**Proposal:** Discharge of Conditions 19 (Ecological Management Plan), Con 23 (Hard Landscaping), Con 24 (Hard Landscaping), Con 29 (Streetlighting), Con 30 (Fire Hydrants), Con 31 (Travel Plan), Con 32 (Public Artwork), Con 36 (On street parking controls) and Con 37 (public infrastructure) of 15/01326/OUT - up to 280 residential dwellings (including up to 30% affordable housing), introduction of structural planting and landscaping, informal public open space and children's play area, surface water flood mitigation and attenuation, vehicular access point from White Post Road and associated ancillary works

DRAWING: **PROPOSED DIVERSION**

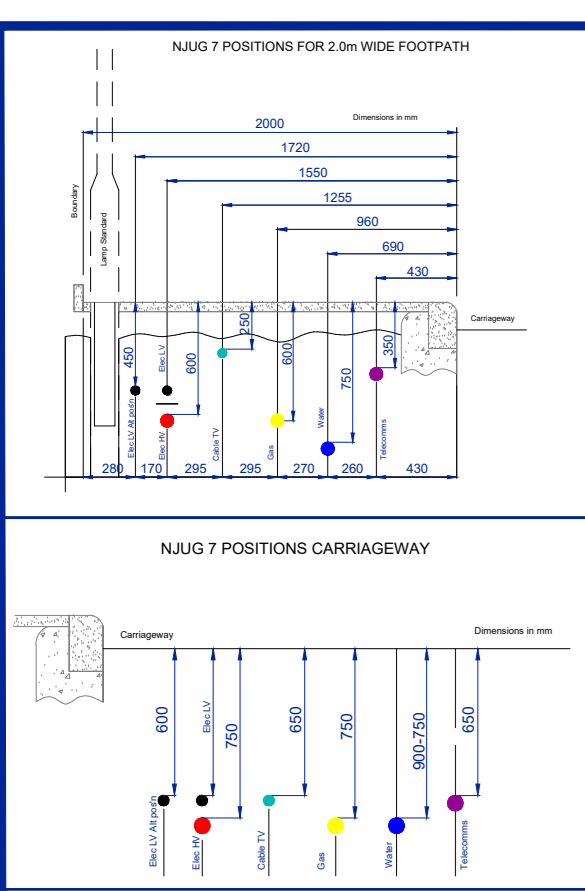
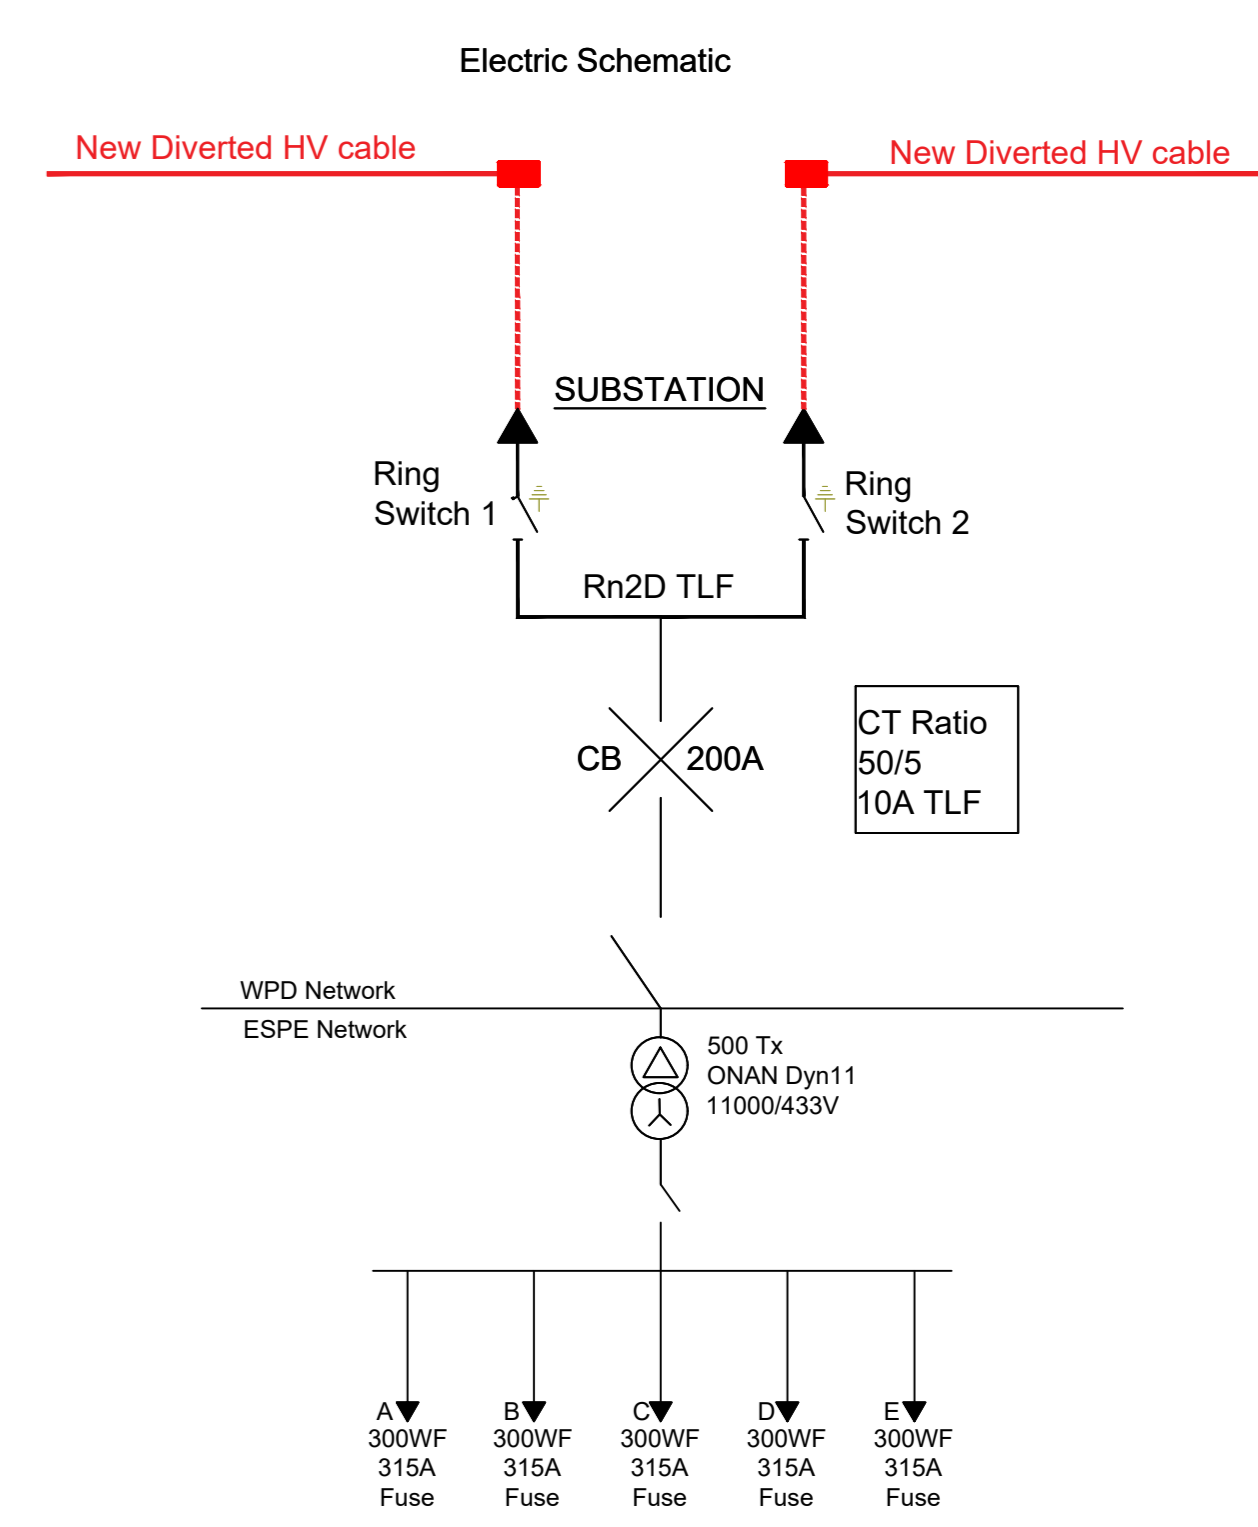
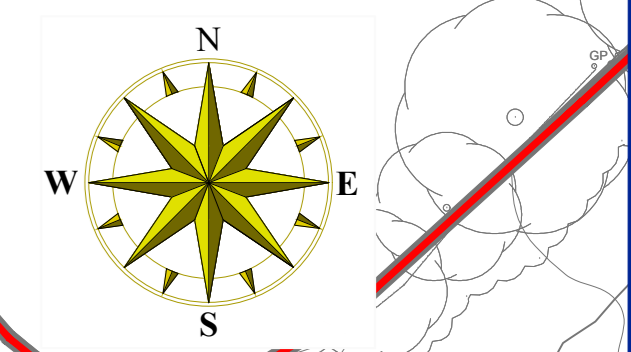
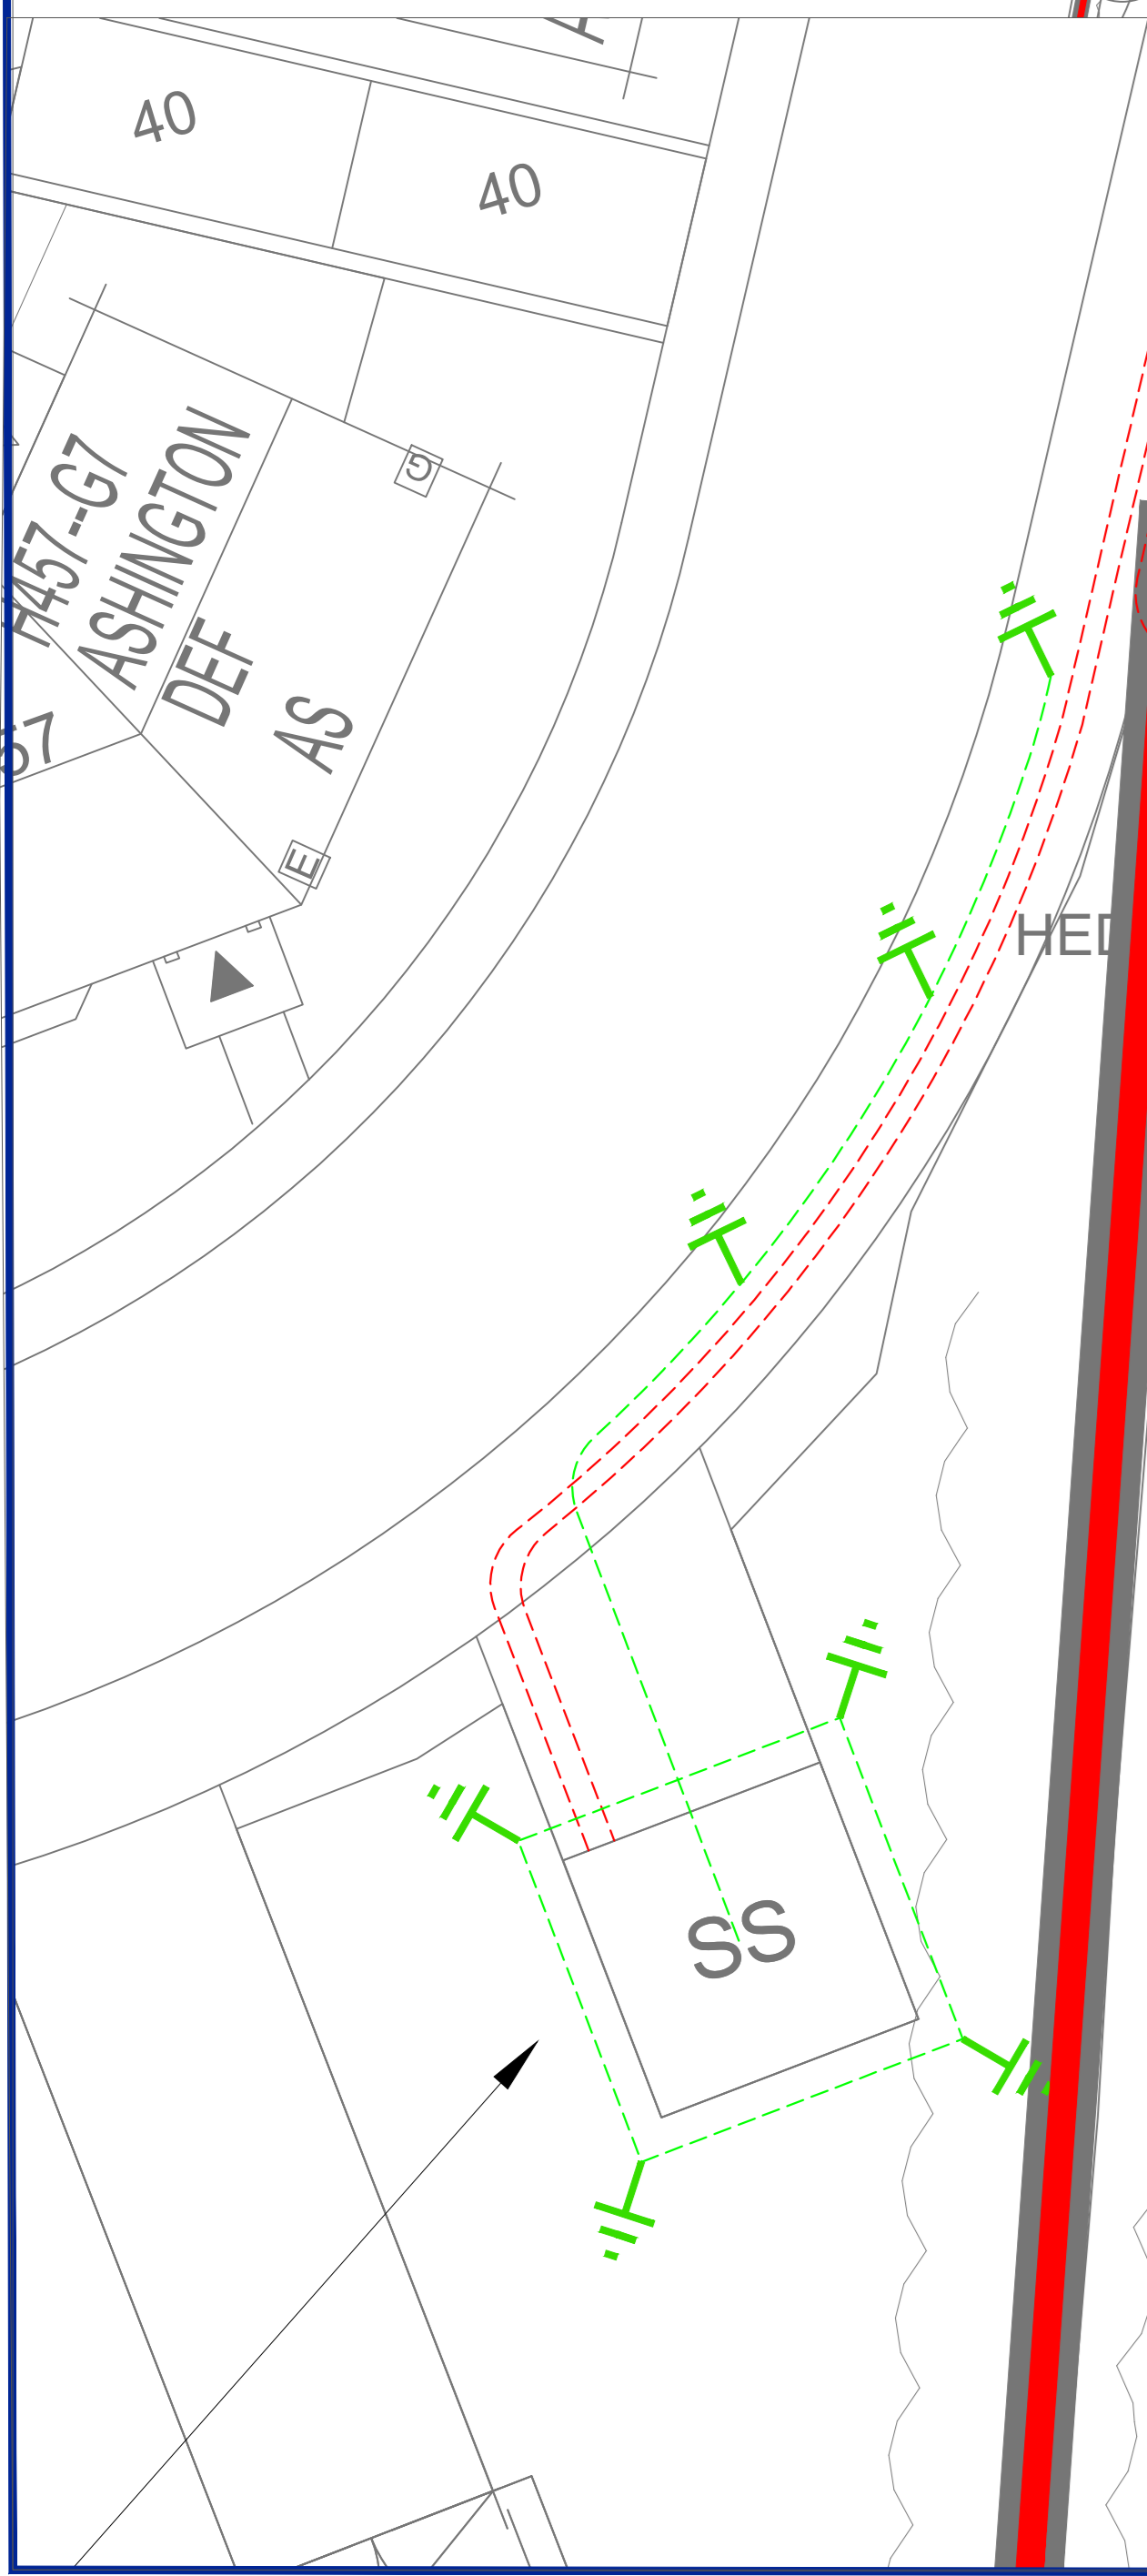
- 5.10 Condition 37 relates to infrastructure provision. A concern was initially raised with the applicant that services were shown running beneath trees and could therefore not be accepted. The applicant has clarified by email dated 25<sup>th</sup> June 2021 that this will be avoided during actual construction works on site. Accordingly, this is now considered acceptable.

Drawing Title
**PUBLIC ART
WATER PUMP FEATURE**

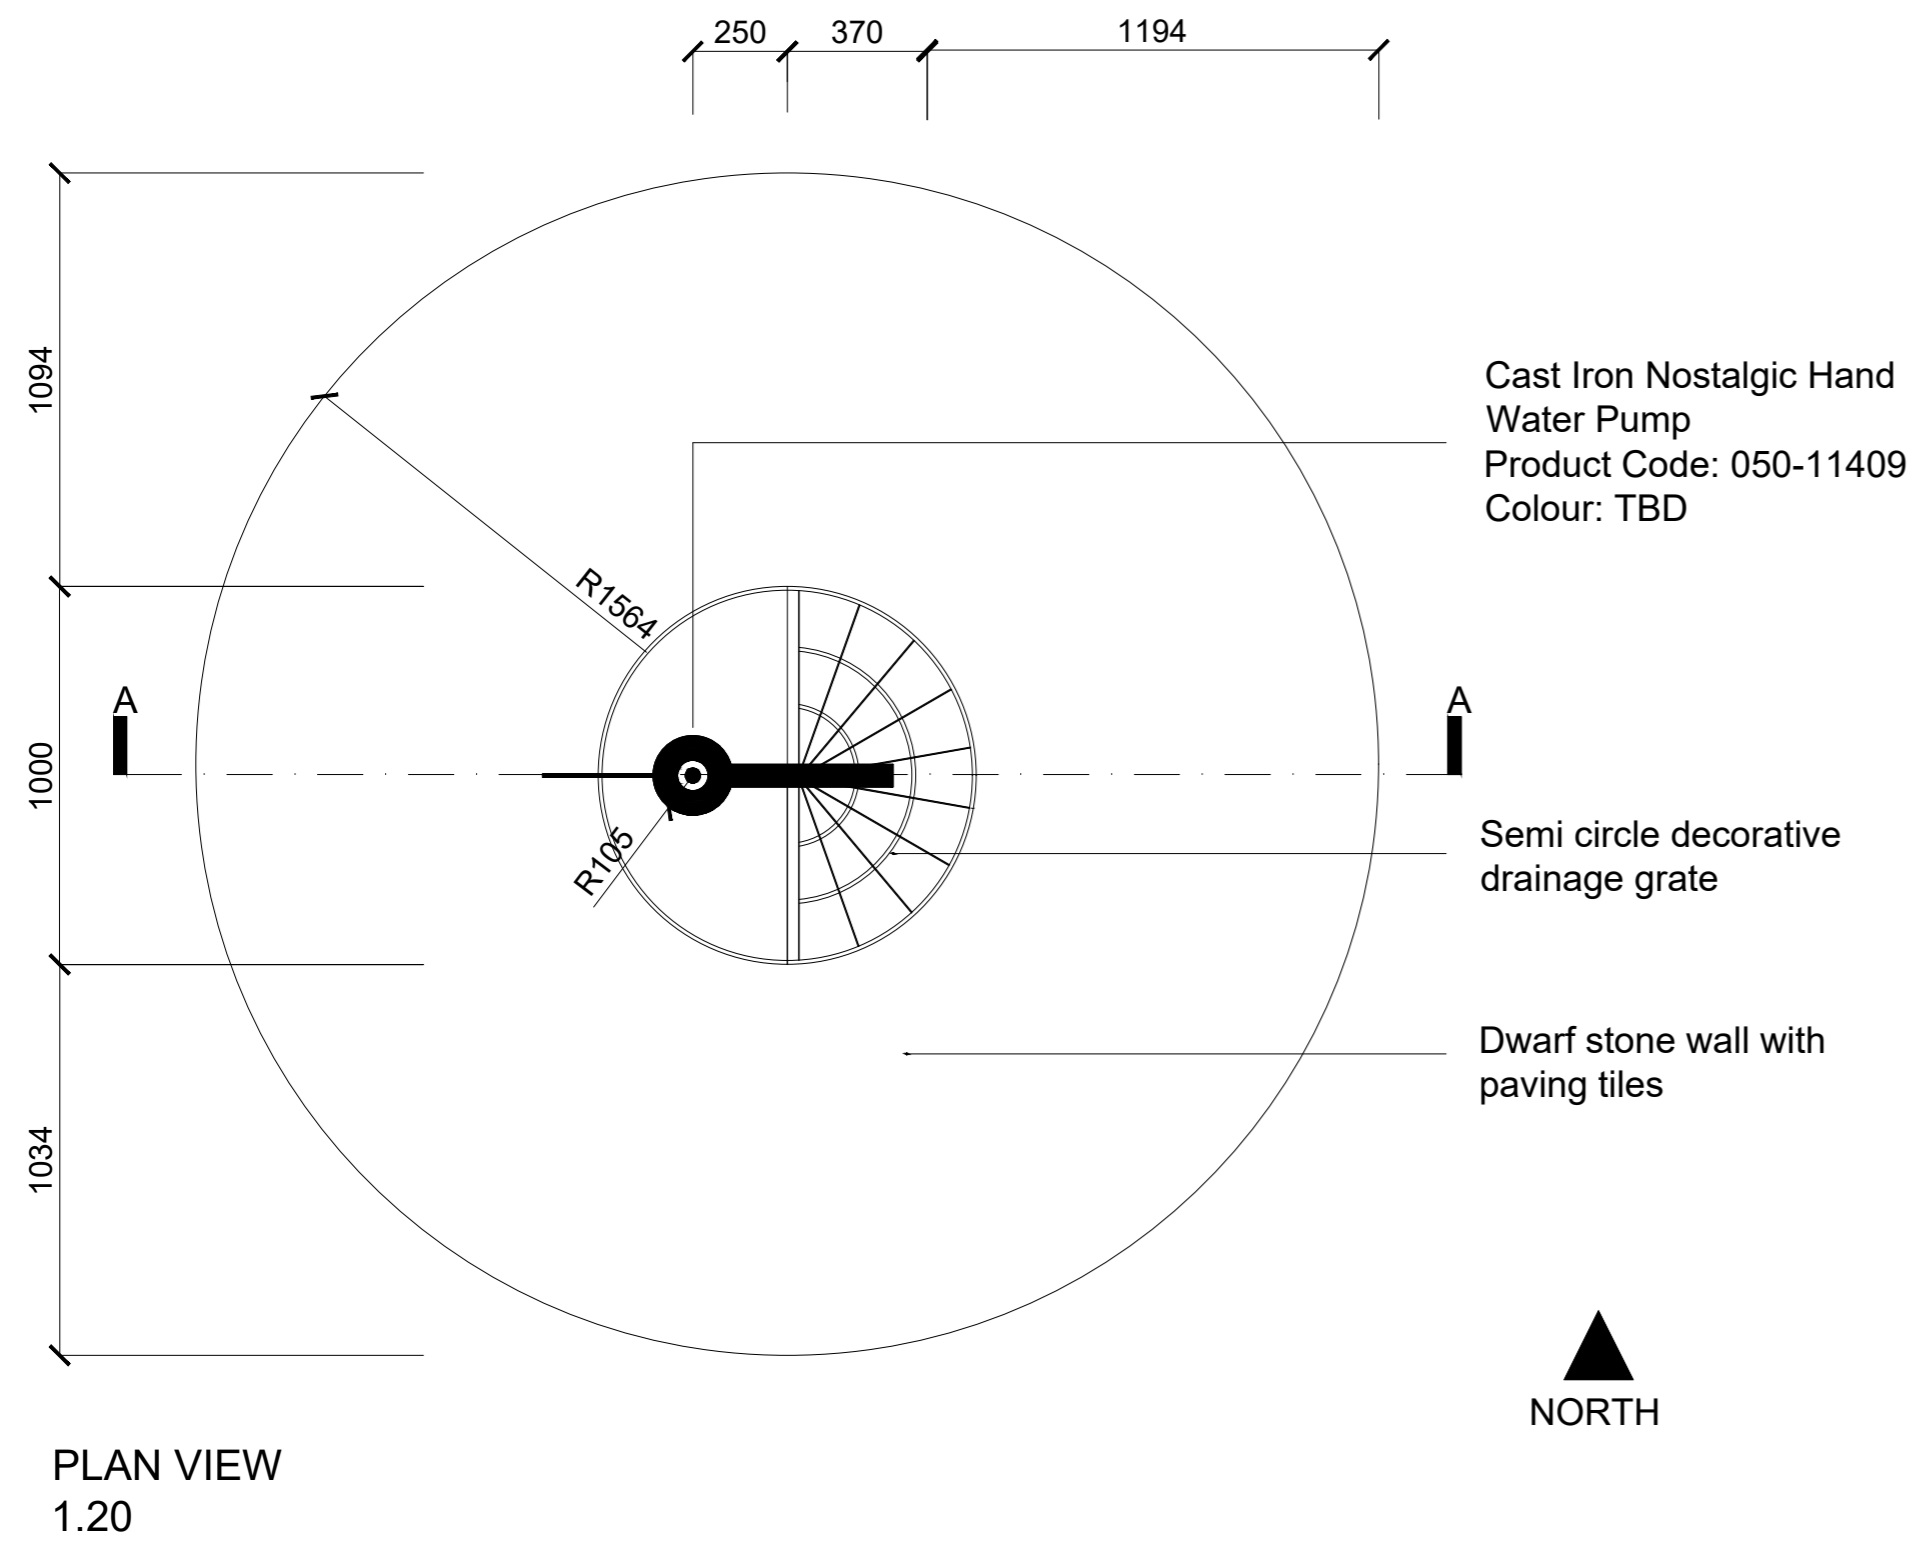
- 5.8 Condition 32 requires details of a scheme of public artwork to be installed to be submitted and agreed. The submission proposes a hand pump to be located within the southern public open space. It is considered that this is insignificant and does not appear to relate to the site context. Comments from a local resident also consider this to be a poor proposal. The applicant was asked to re-consider the proposal and provide something more meaningful. Regrettably, the applicant has declined to do so. Whilst it is considered that this is a very poor and unimaginative submission, it is unlikely that a refusal could be substantiated on this ground alone at appeal. It is therefore regrettable but recommended that the condition be discharged as submitted.
